Rezoning Transportation Analysis

Petition Number: #2022-048

Date	Description
08-25-22	First Review (PDM)
09-22-22	Second Review (PDM)
10-27-22	Third Review (TM)

RZ-2

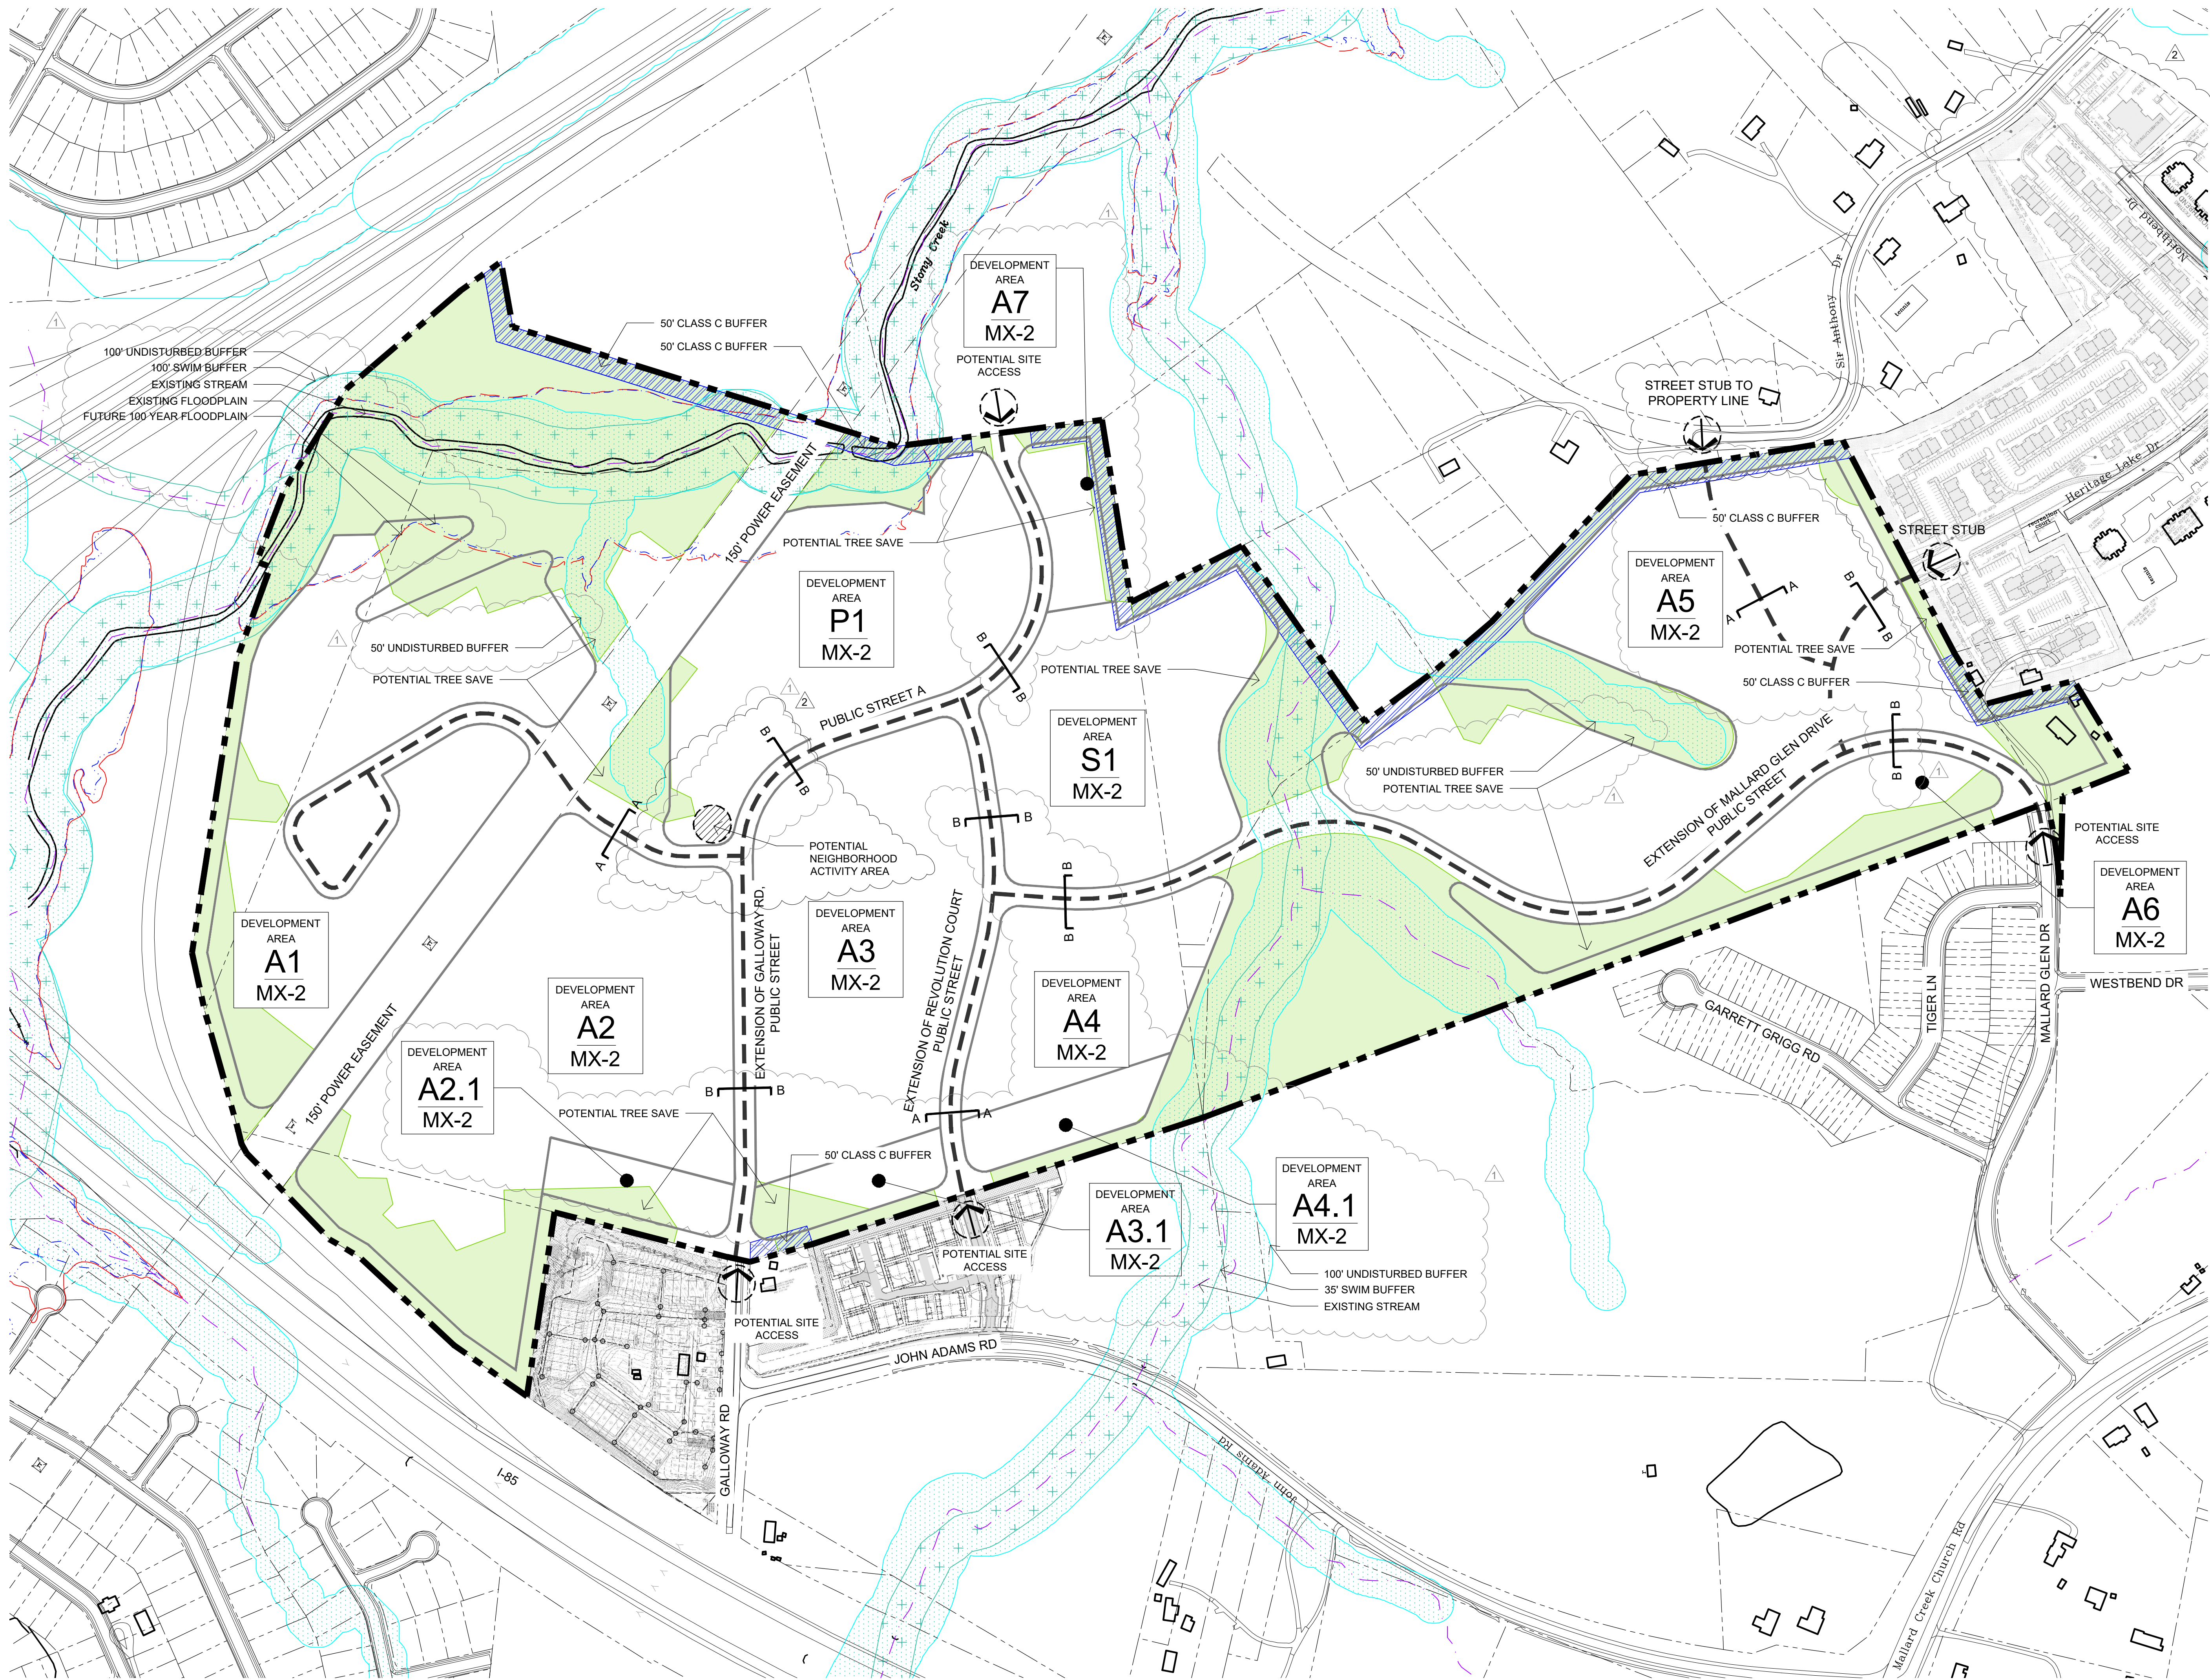
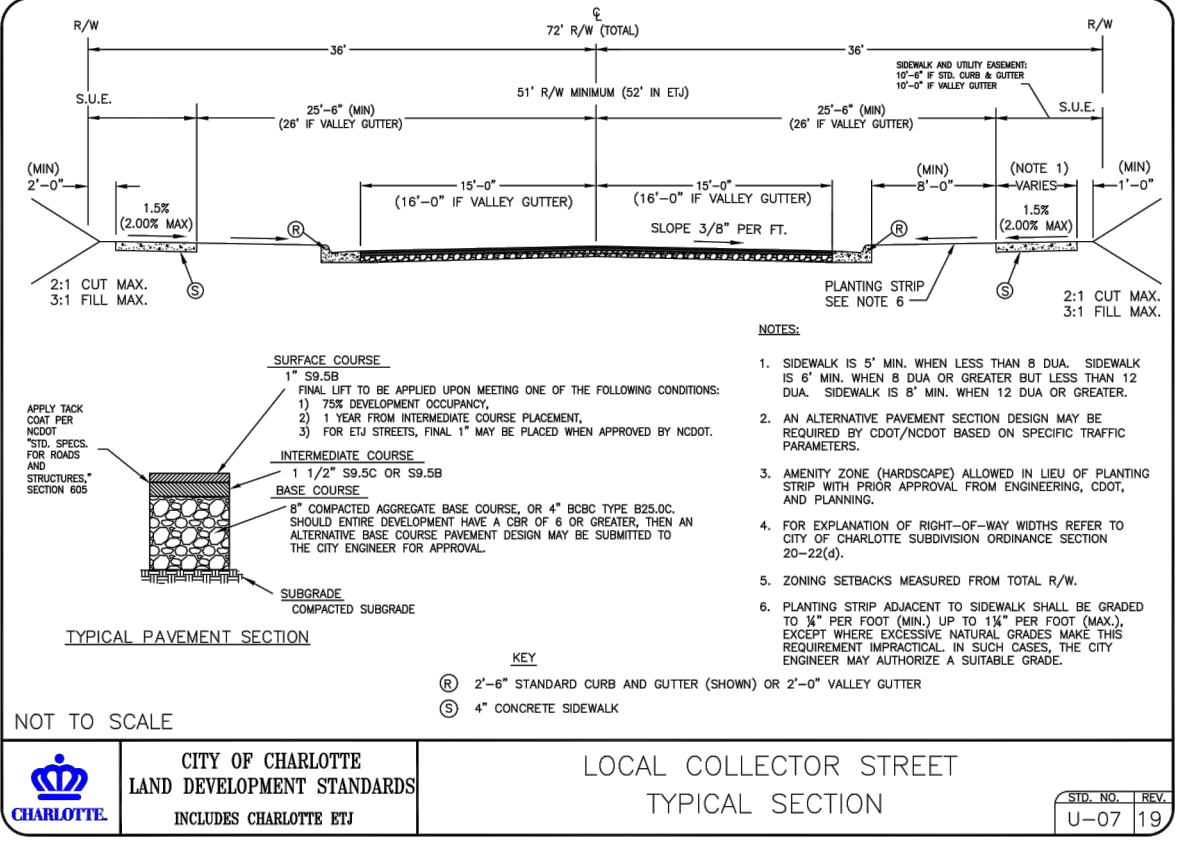
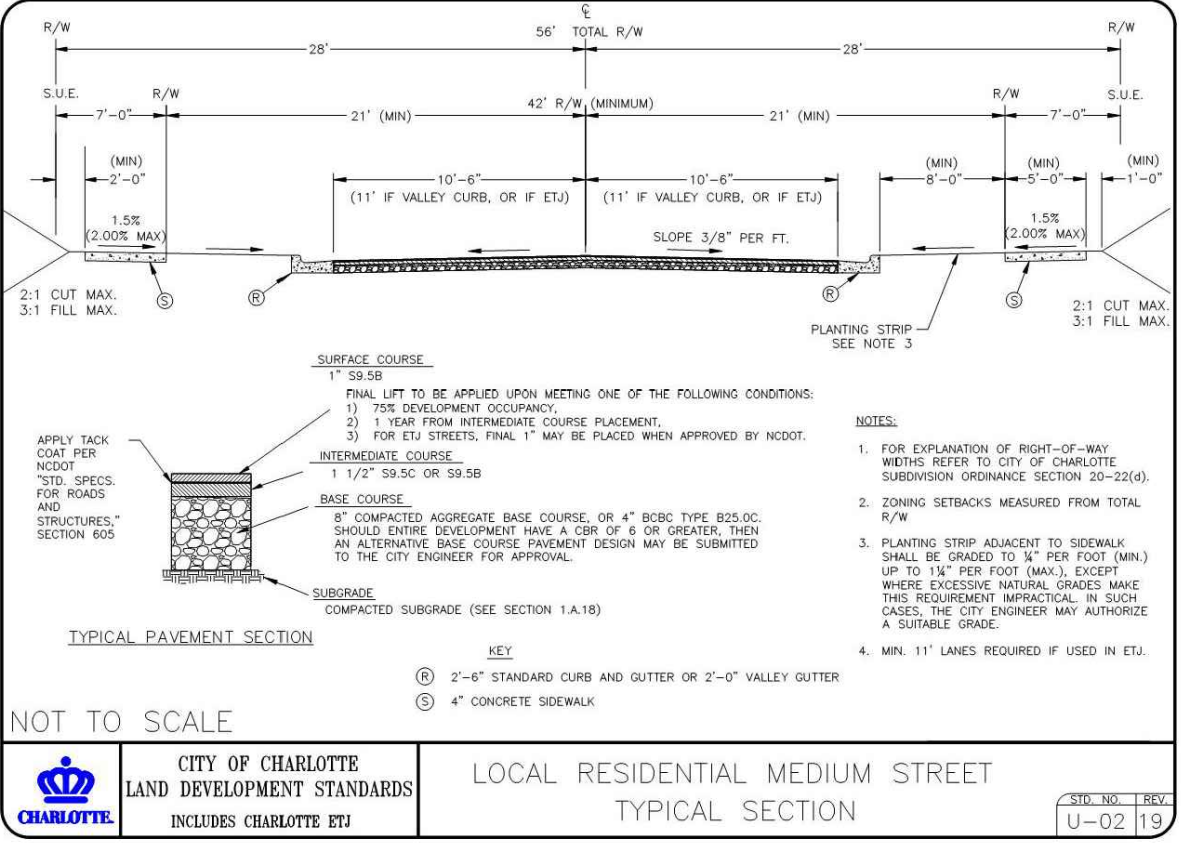
~~2. **Outstanding Comment from 08-25-22:** Revise site plan and conditional note(s) to commit to improving the existing Galloway Road stub to John Adams to the local collector street typical section per U-07.~~

- ~~3. Revise site plan and conditional note(s) to commit to the proposed roadway network typical sections and proposed phasing outlined in the Traffic Impact Study. Provide typical sections per CLDSM for all proposed public and private streets. Provide 8 foot sidewalk and 8 foot planting strip on all public streets.~~
